PLANNING AMENDMENT

Application No. H13/0929/02/A1

PLOT 1, OFF THE SIDINGS, MOWTON.

ERECTION OF HOUSE & DETACHED GARAGE.

Drawing No.
36 C

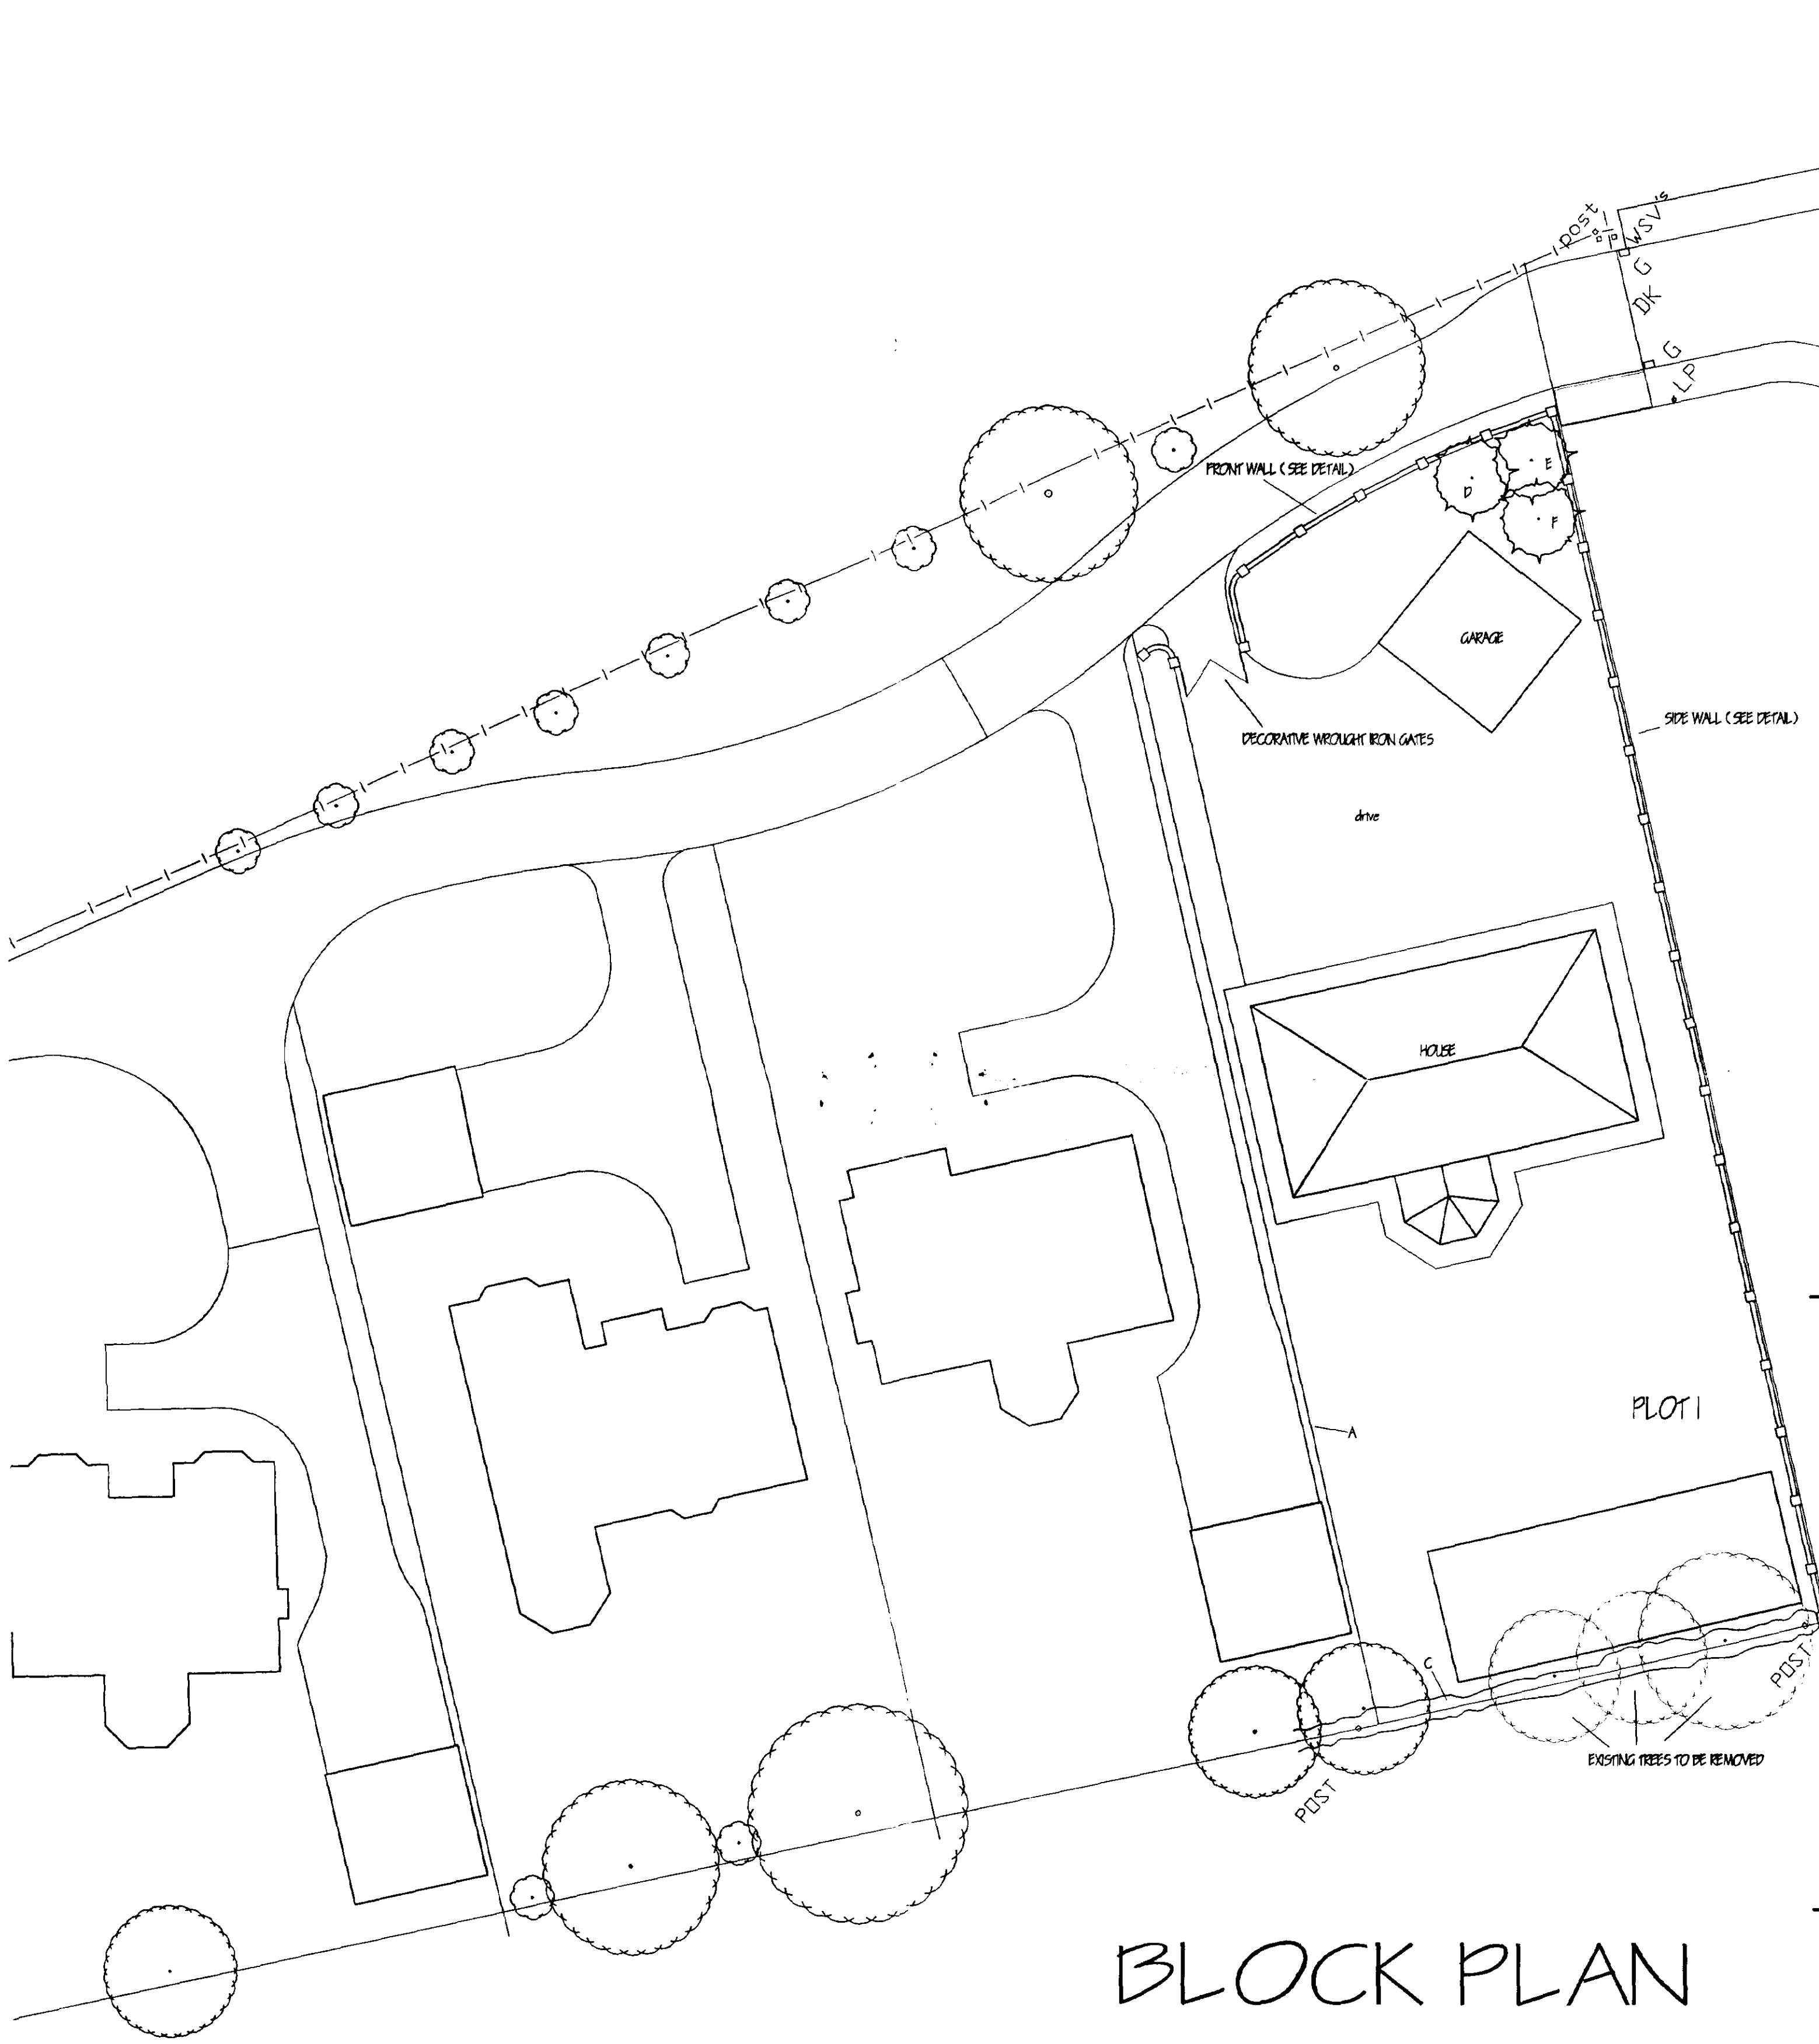
CUPOLA ADDED TO GARAGE.

Amendment: Cupola added to garage.
Dwg no. 36C
